Planning Department
Alan Varela, Director

May 26, 2022

Re: Titan 150K Spec Building - Daytona Rd. NW
ESC Plan Engineers Stamp Date: 4/21/2022 – K09E051

<div>ENGINEER'S SEAL</div> <div></div> <div>RONALD R. BOHANNAN P.E. #7868</div>	TITAN 150K SPEC BUILDING ALBUQUERQUE, NM	DRAWN BY pm
		DATE 4-21-2022
	EROSION CONTROL PLAN	DRAWING 2020088-150K-SWPPP.DWG
		<div>SHEET #</div> <div>SW-1</div> <div>JOB # 2020088</div>

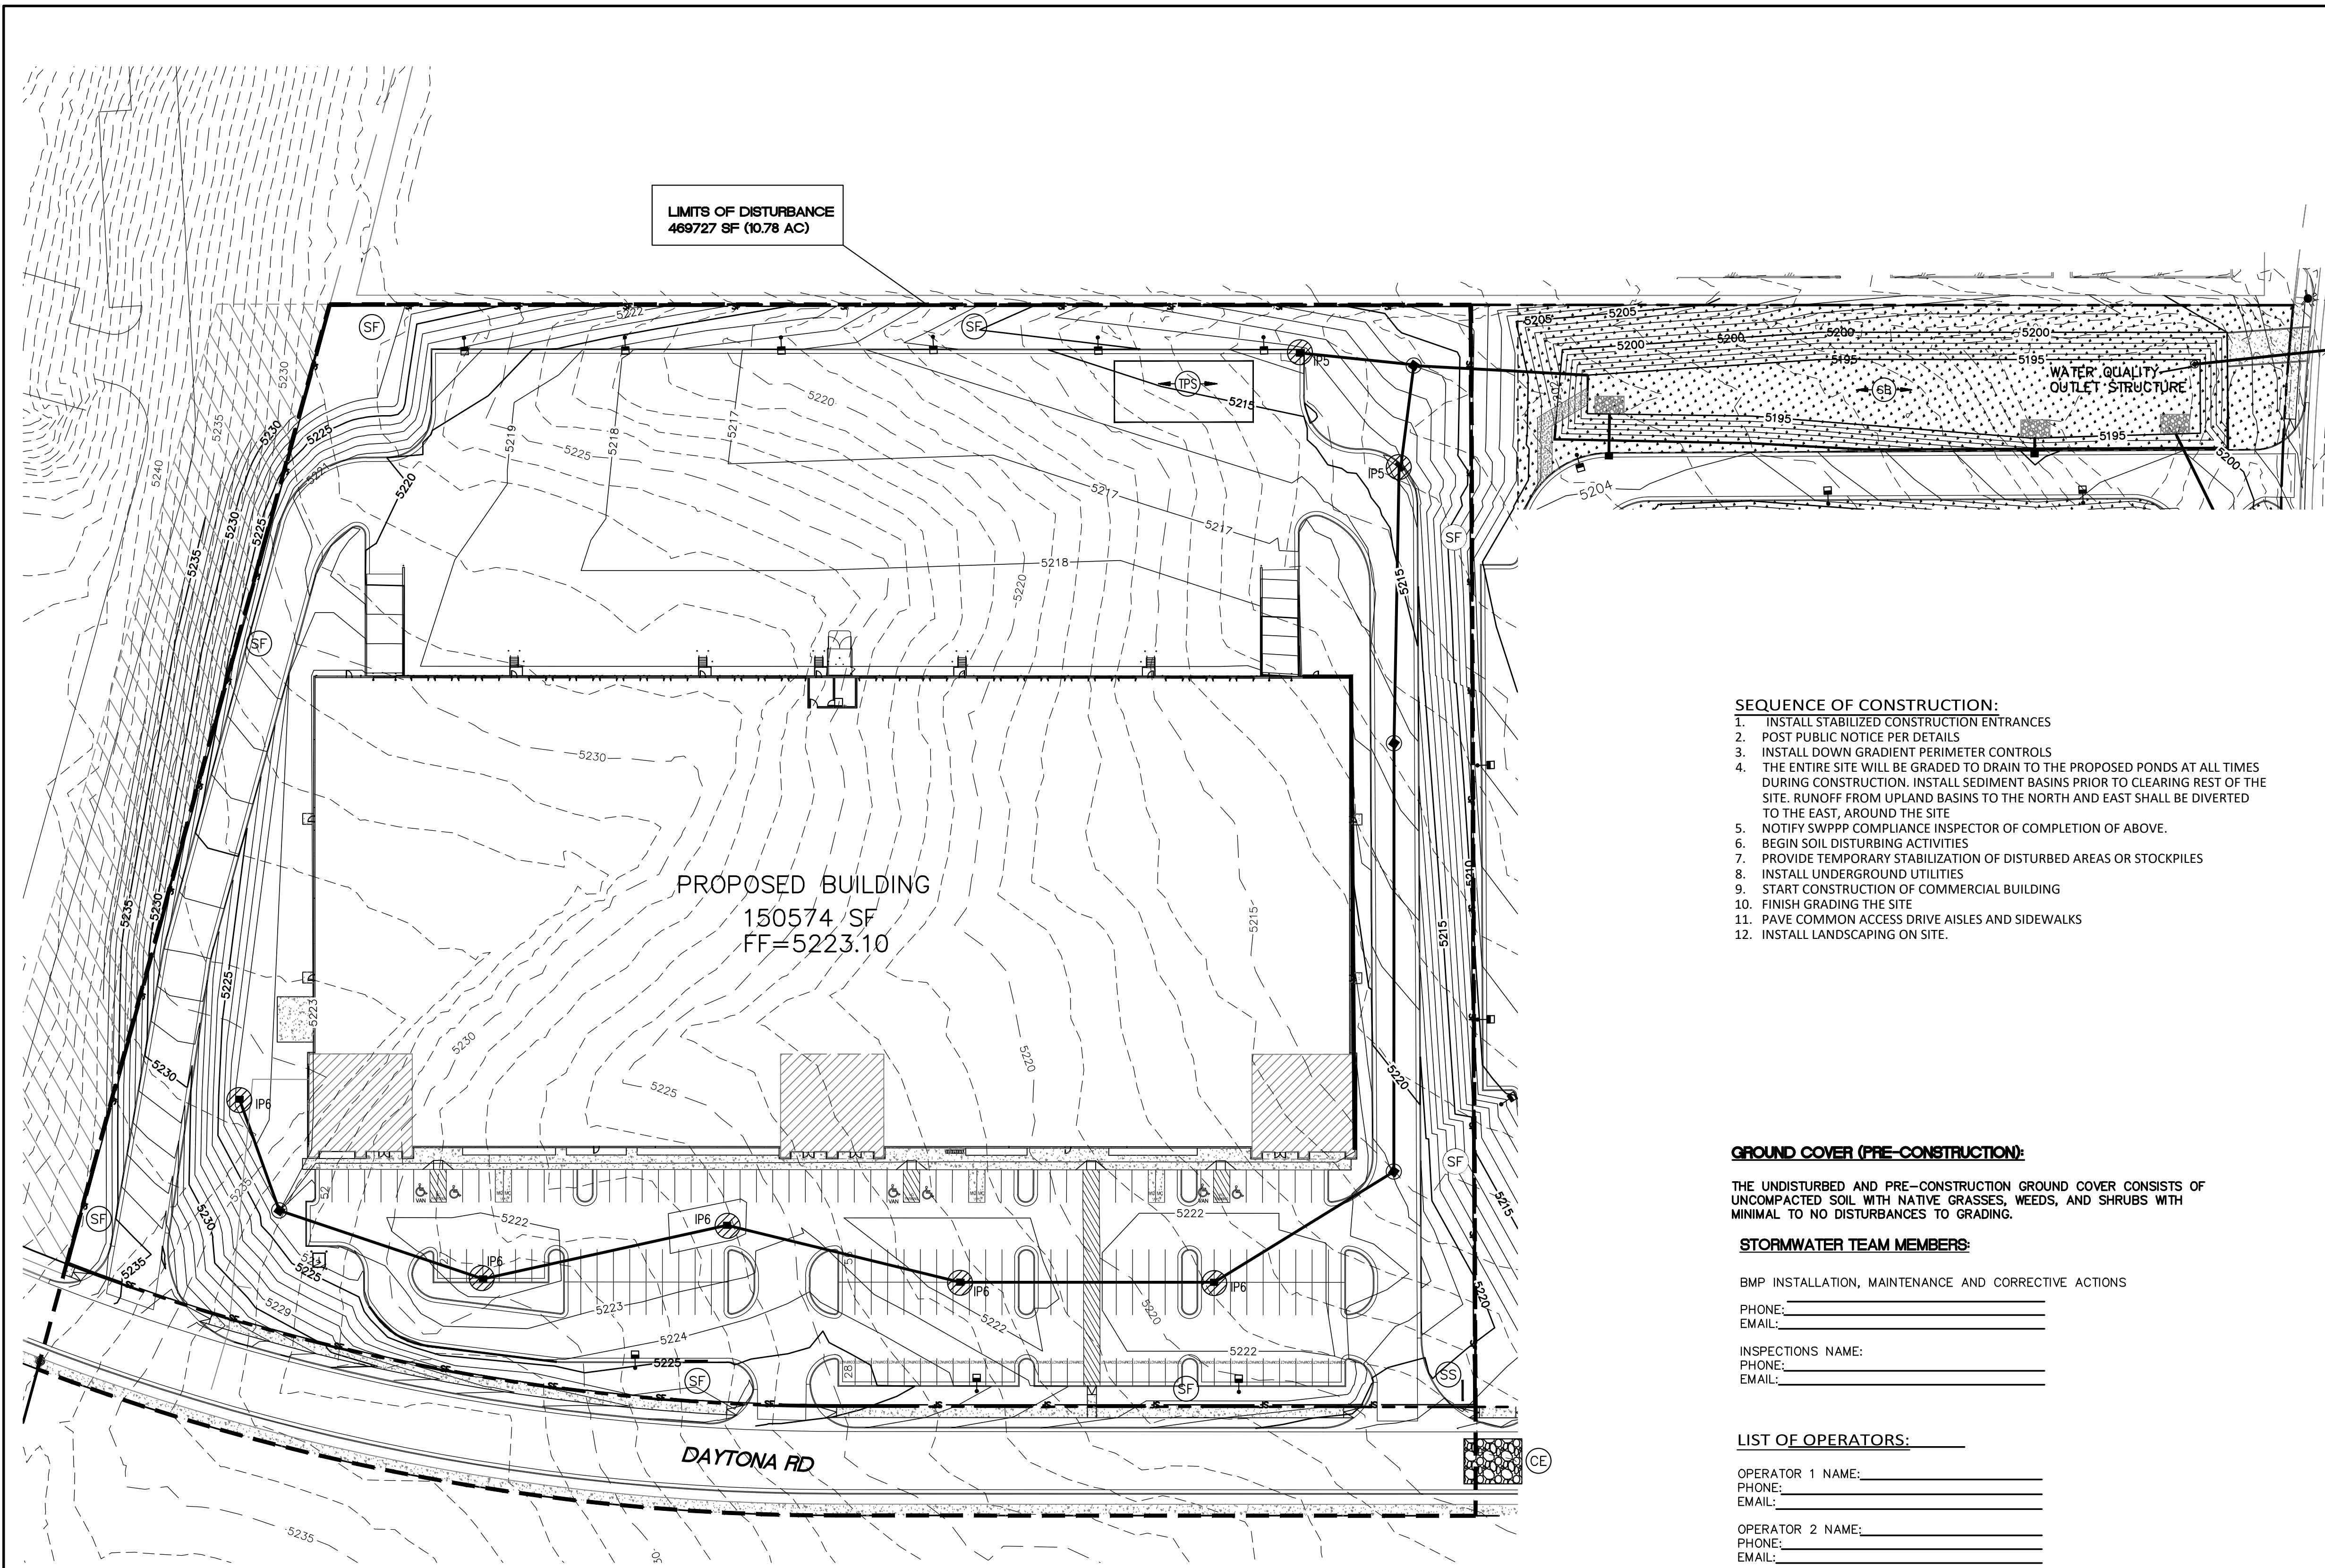
3. Soil information – add a table with name type, particle sizes, and Erodibility factor (CGP 2.1.1).
4. The Limits of Disturbance should be moved to the limits of the grading north of the site and so should the silt fence.

5. The silt fence should be moved to the limits of disturbance on the west sides of the site.
6. Update the engineer's stamp date each time the plan is changed.
